Application No: AW/422/21/HH
Site Address: 24 Lincoln Avenue Aldwick PO21 3EJ
Description of works: Single storey rear extension and first floor dormer.

Thank you for your internet representation made on 5th March 2022 which has been recorded as an objection with the comments as follows:

Proposed First Floor Plan

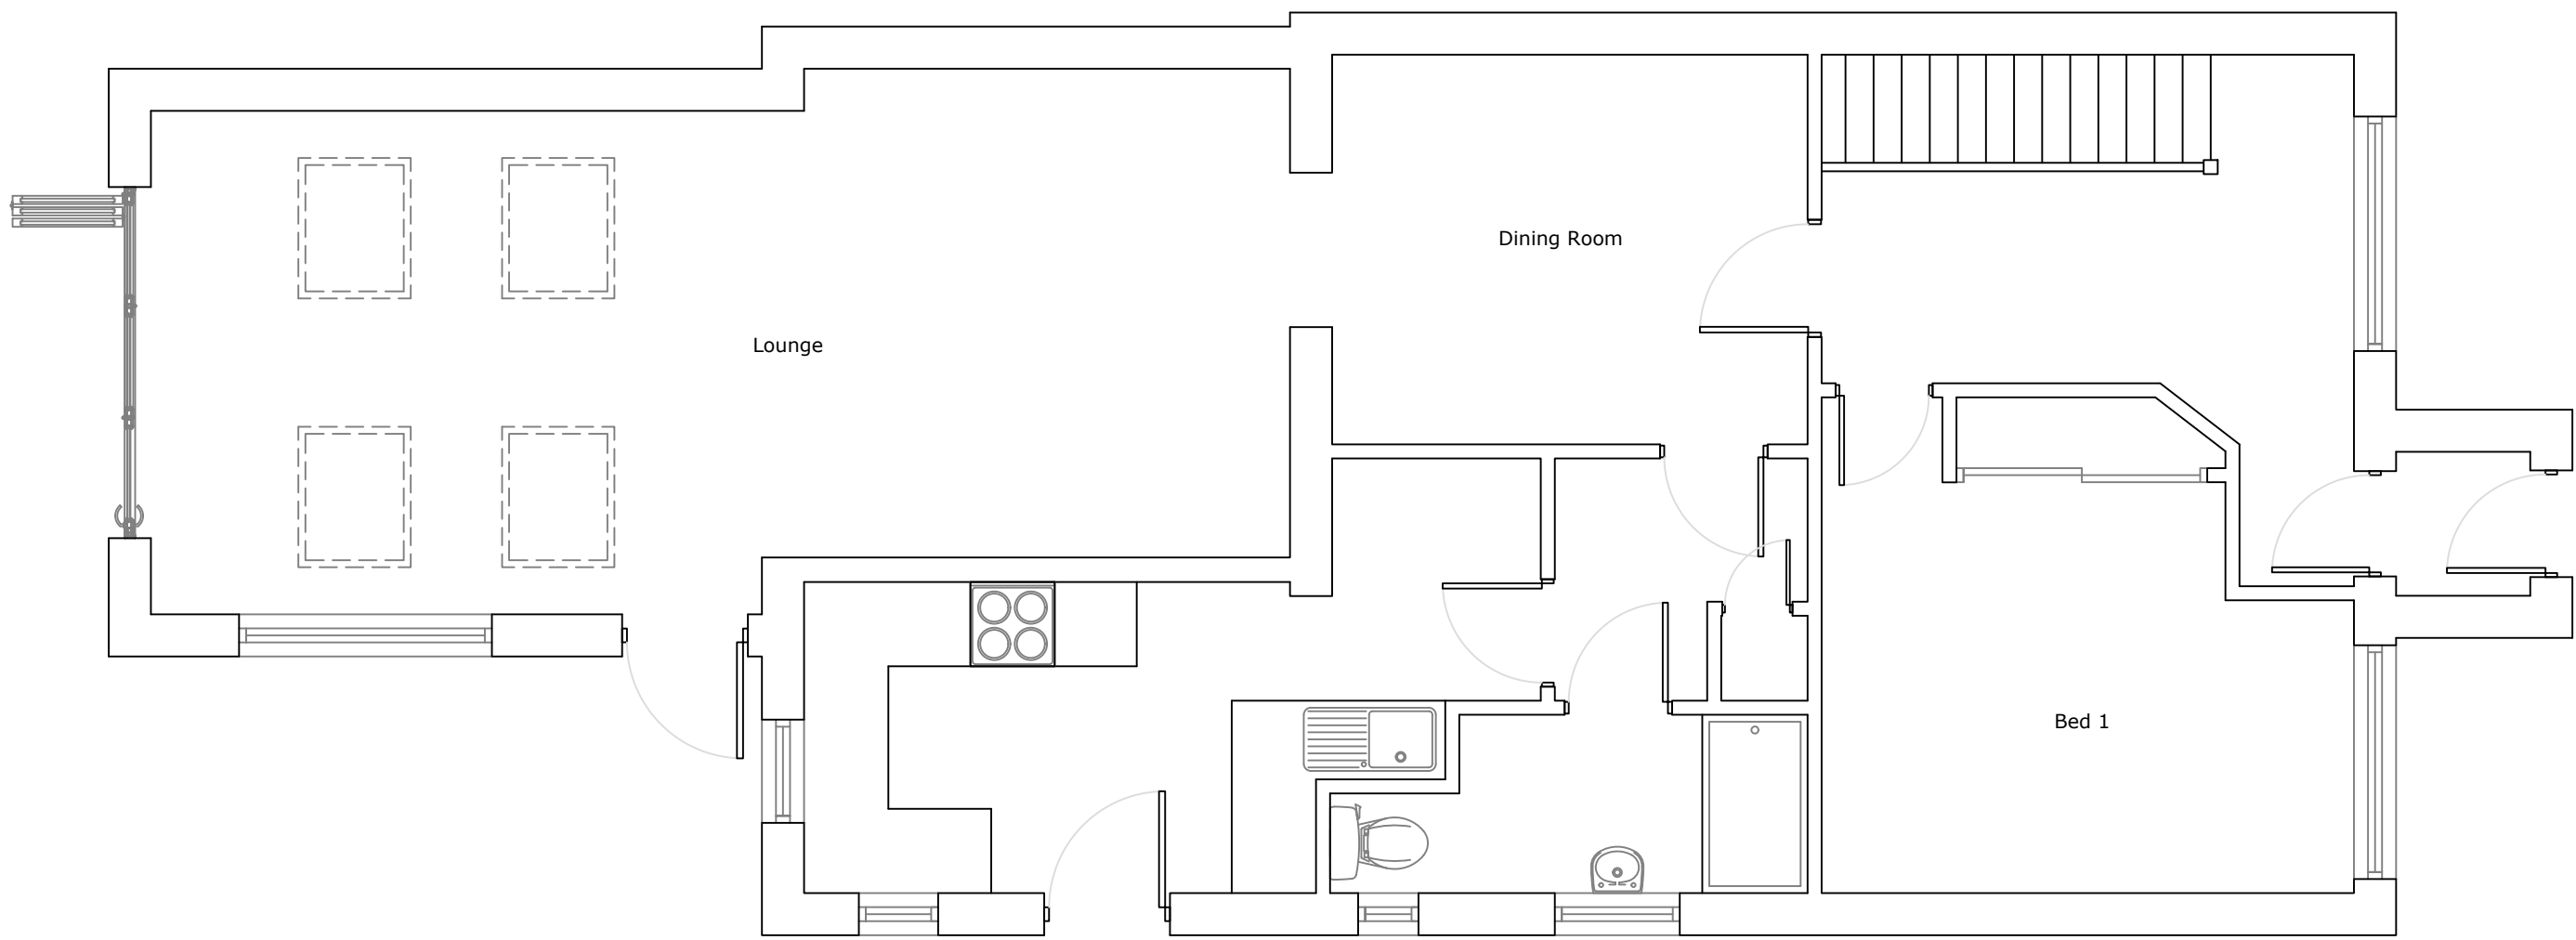
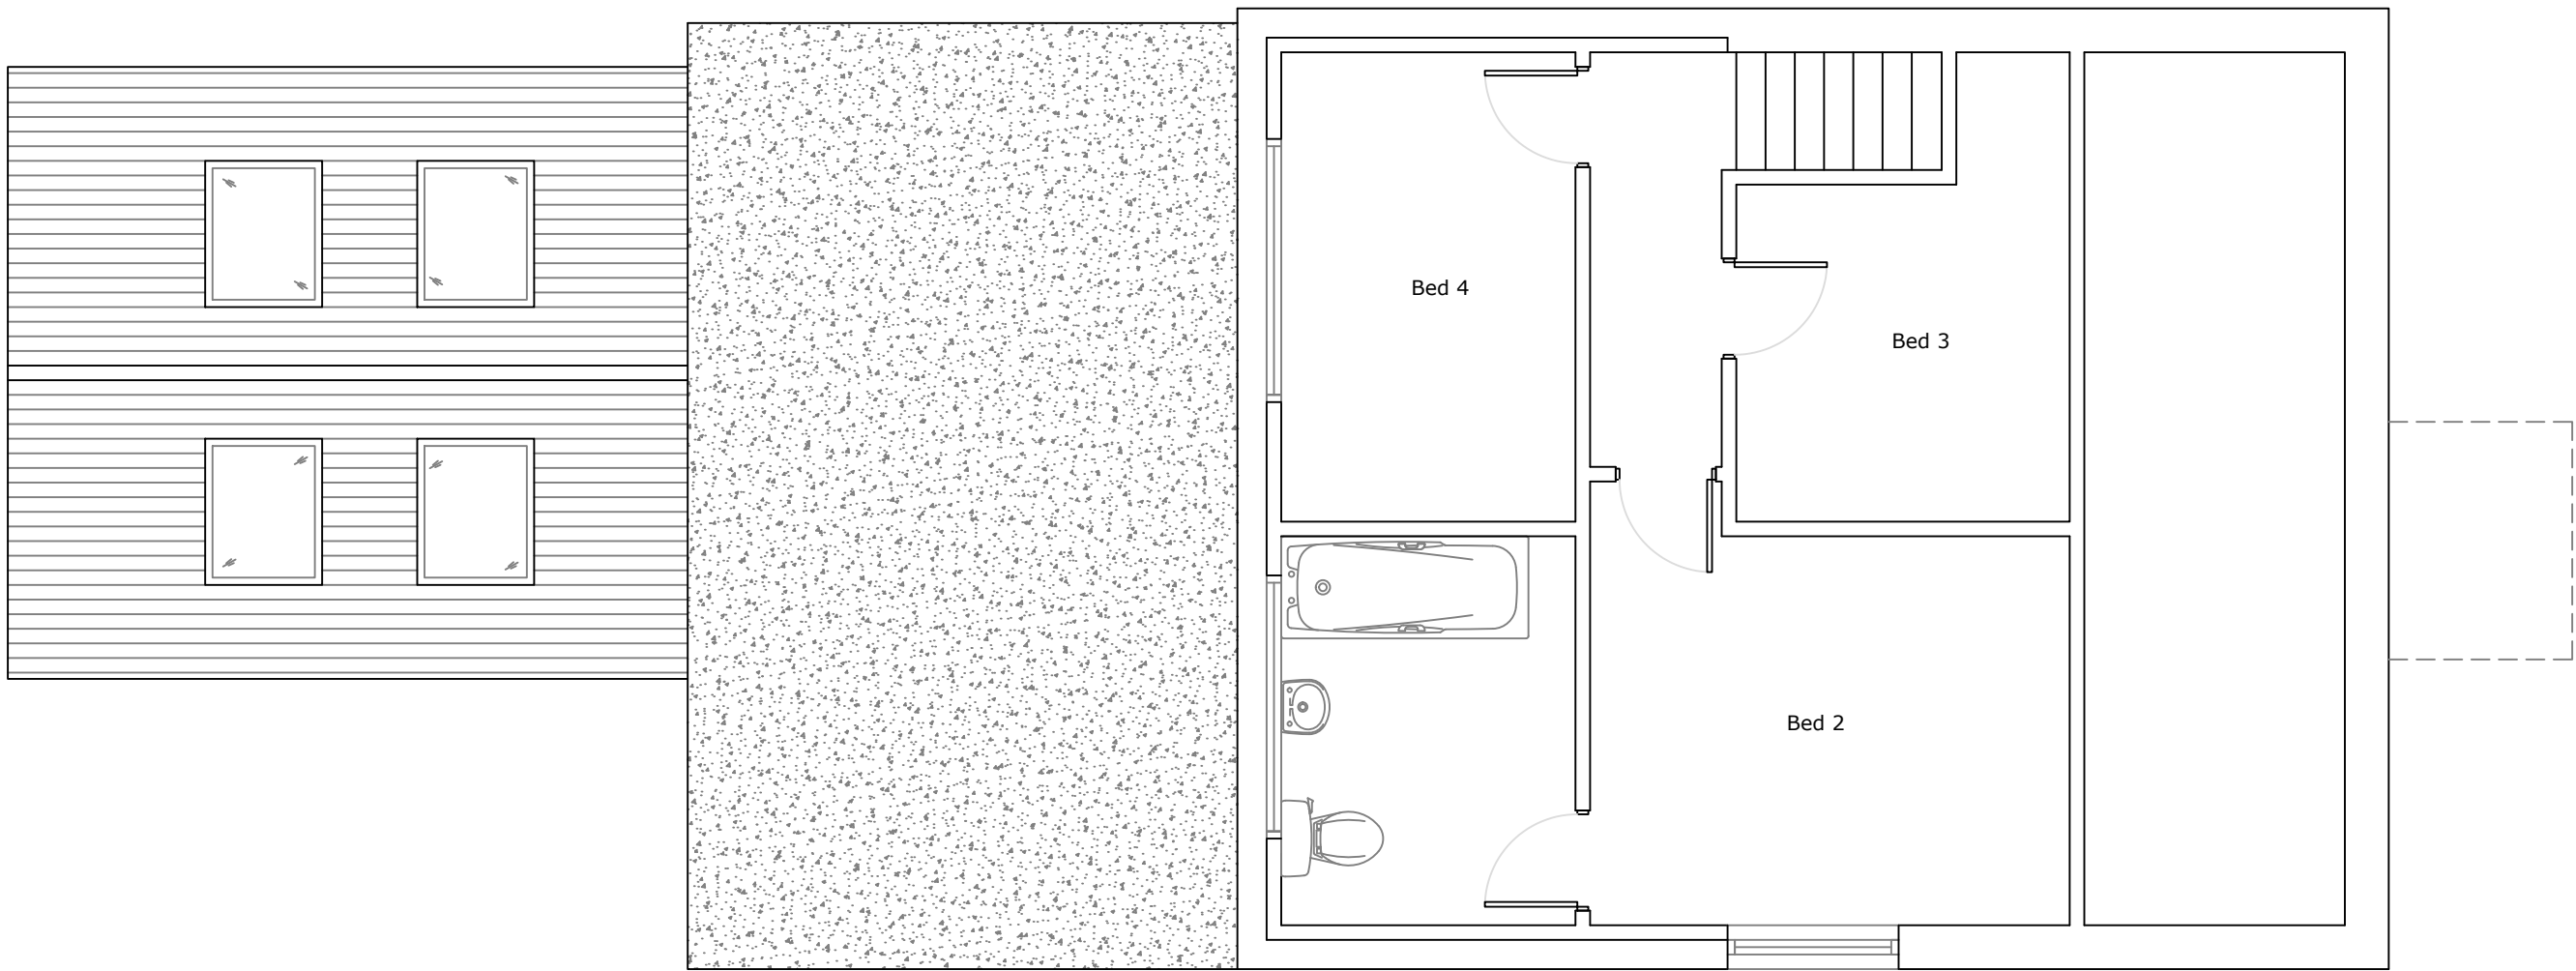
Our property is a bungalow which borders number 24 Lincoln Avenue, the proposed first floor Dormer in this application would facilitate a direct line of sight into our living accommodation, which would be an invasion of our privacy and completely unacceptable.
